From: Julie Grieves on behalf of Planning.Responses
Sent: 25 July 2019 10:01
To: Planning Scanning
Subject: FW: LU/131/19/PL & LU/132/19/L

LU/131/19/PL & LU/132/19/L

Number 20 Western Road is an Early-mid 19th century, Grade II two-storey Listed Building. It has a slate roof with Horsham slabs at base. It is pebble fronted with red brick dressings on ground floor, whilst the 1st floor is red brick with modillion eaves cornice. The front elevation of the building indicates that it has been adapted and changed over time. Windows are sliding sash to the front elevation.

Drawing title
Proposed Changes

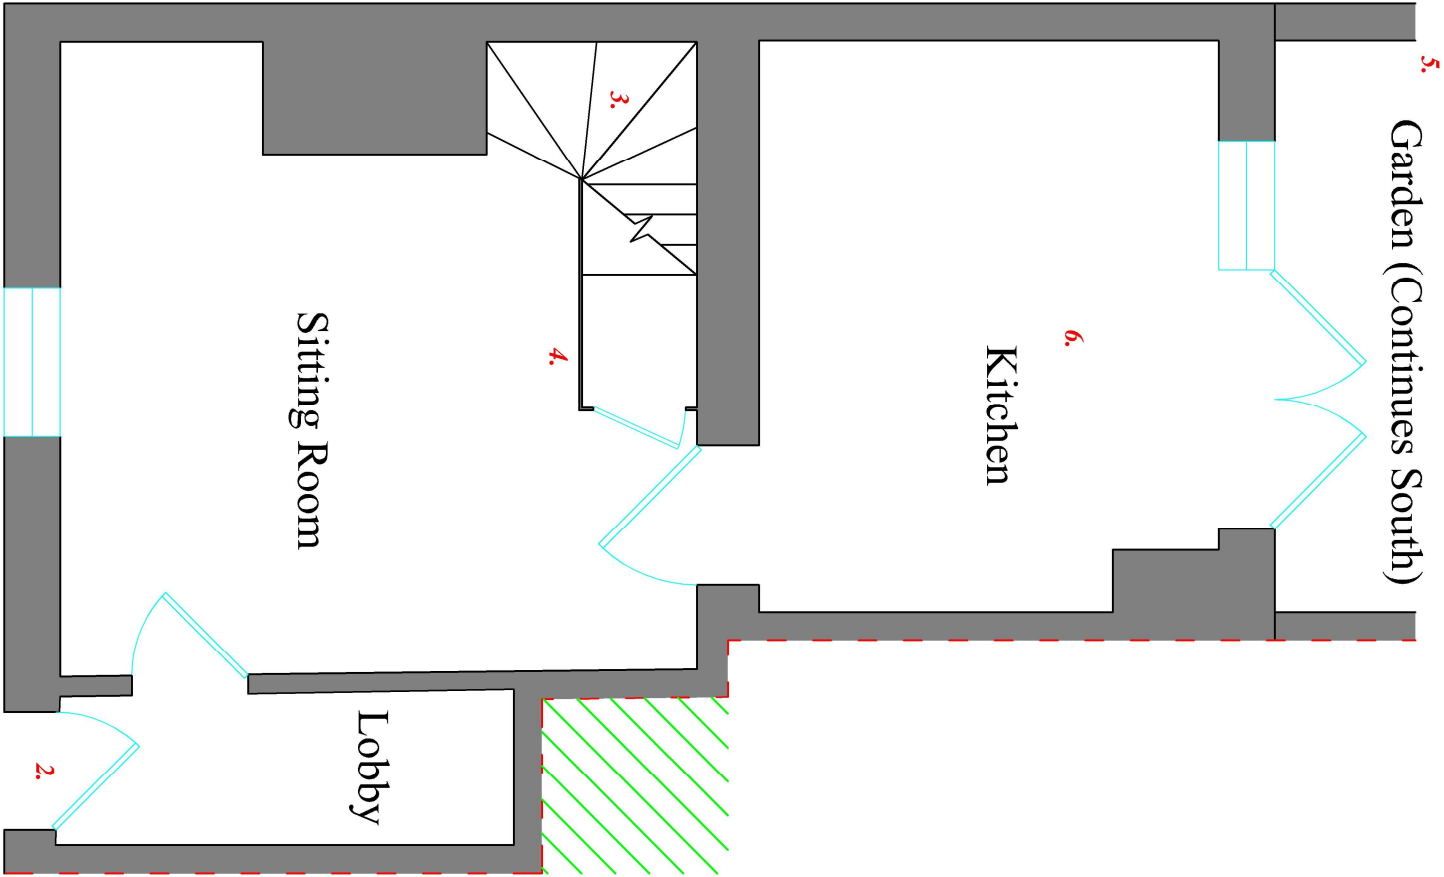
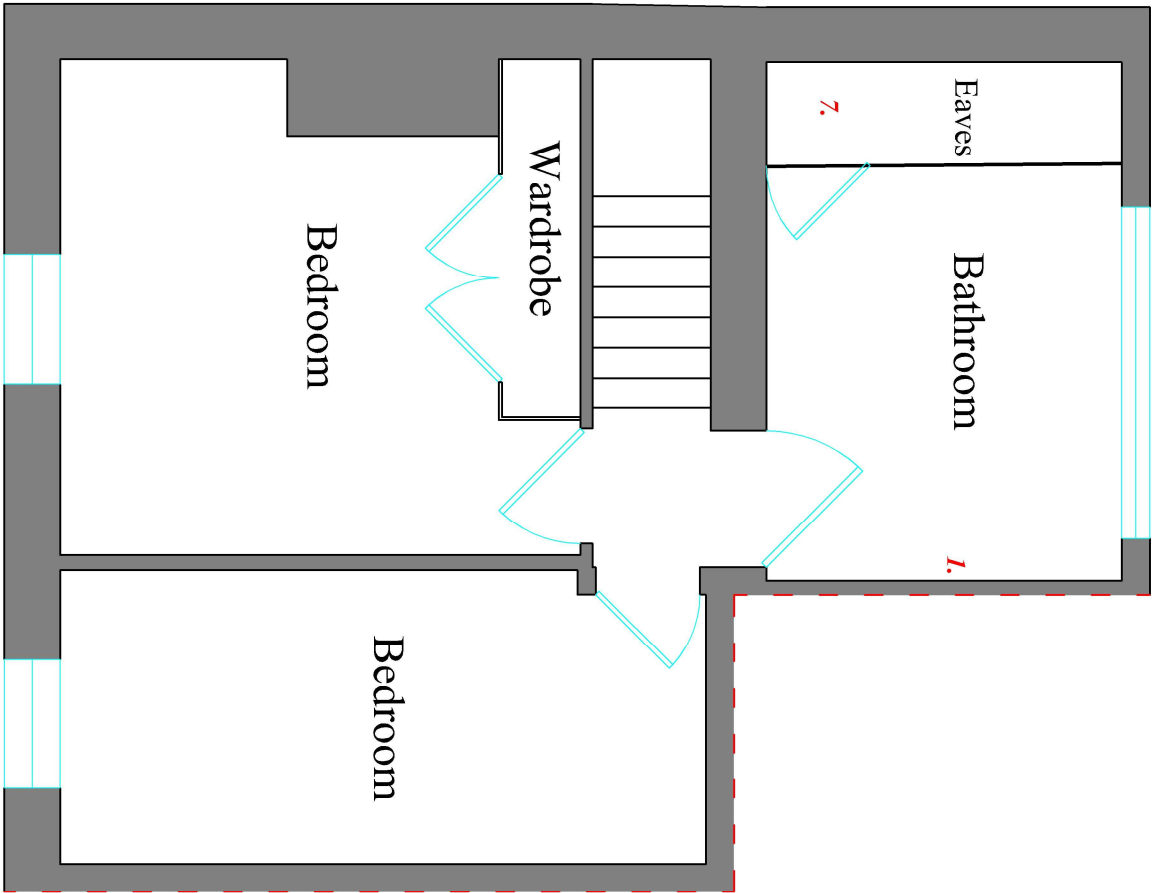
Whilst the concept of repointing is acceptable, it is not clear if the intention is to repoint an entire elevation or more. Could this be confirmed please?

I note that reference is made to the fact that a sample of the mortar used for the original construction would be analysed to ensure that the same one is used for the works. Such a proposal is considered to be appropriate, and suitable for the building, and the impact that the works could have on the external appearance of the building. The style of pointing should be confirmed with the applicant.

Further, the heritage statement indicates that some of the existing brickwork is damaged. If it is to be replaced, it should be undertaken on a like-for-like basis.

The concept of replacing the stairs is considered to be acceptable, subject to them looking like they do now. Works to remove the existing fabric should be undertaken carefully so as to not harm the historic fabric. All historic fabric should also be carefully re-instated.

The intention is to try to repair and restore the front door is supported as it will allow older fabric to remain in-situ. If replacement is required, this should be done on a like for like basis. It might be worth the applicant informing the LPA if the door is to be replaced and provide information to confirm that the replacement will be a direct copy.

Whilst the proposal is acceptable, materials must be used which reflect the existing walling. As before, a mortar sample can be sent for analysis in order to ensure that it reflects the existing material. The style of the pointing should also reflect the property/the existing style.

Drawing title
Roof Plan

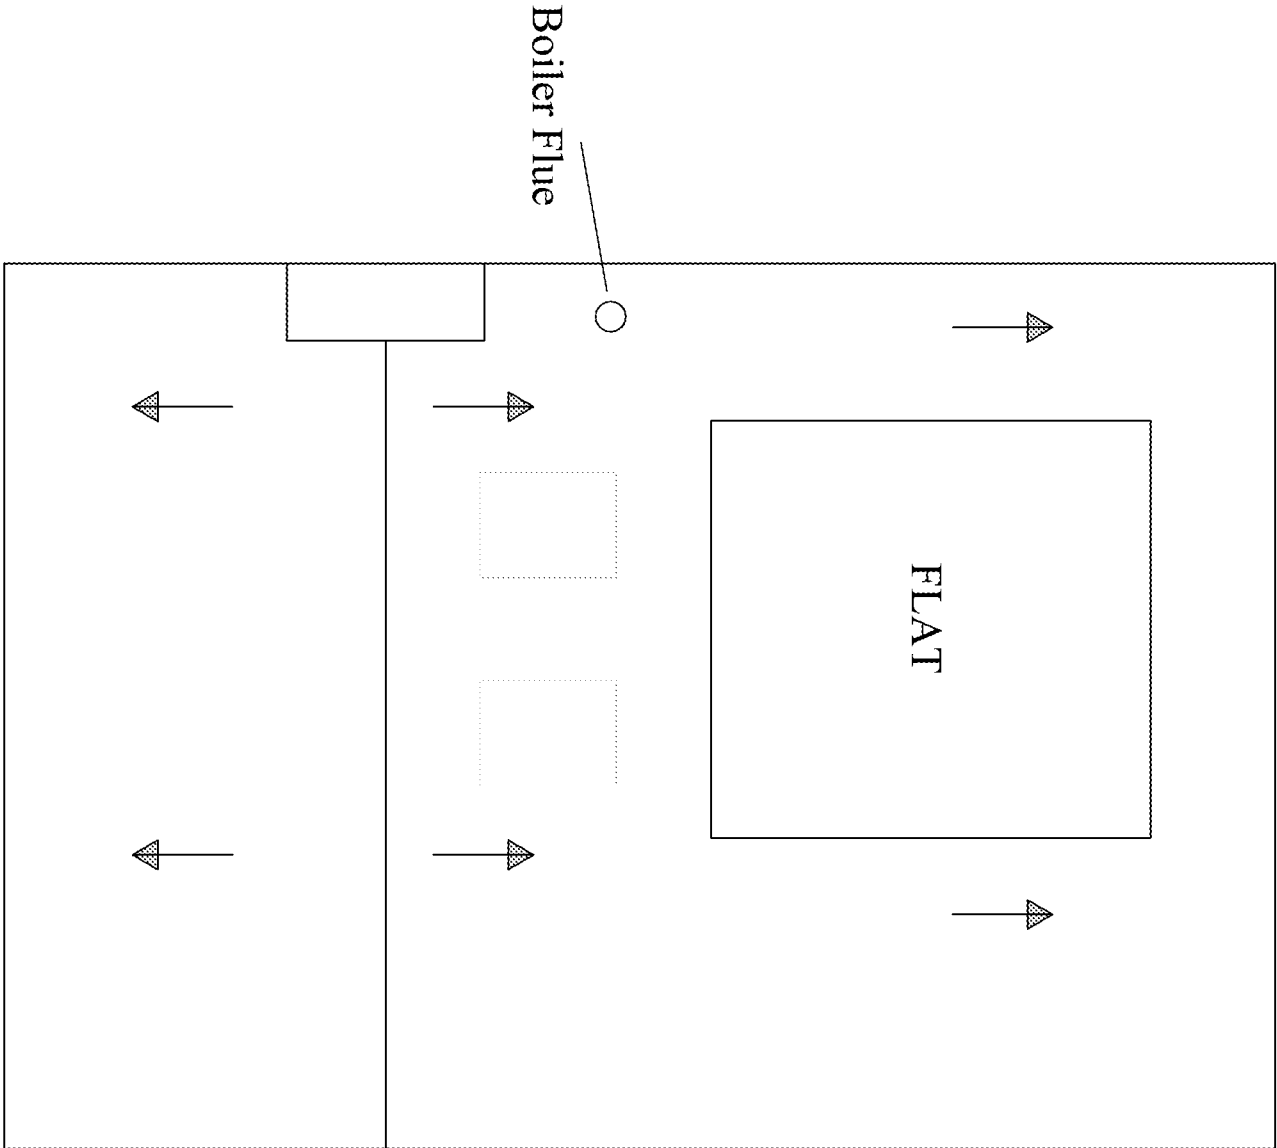
The location and appearance of the flue are considered to be acceptable. For information, it should be treated in a black colour to reduce its impact.

It would be positive if the applicant were to upgrade the existing rear rooflights so that they are of conservation standard.
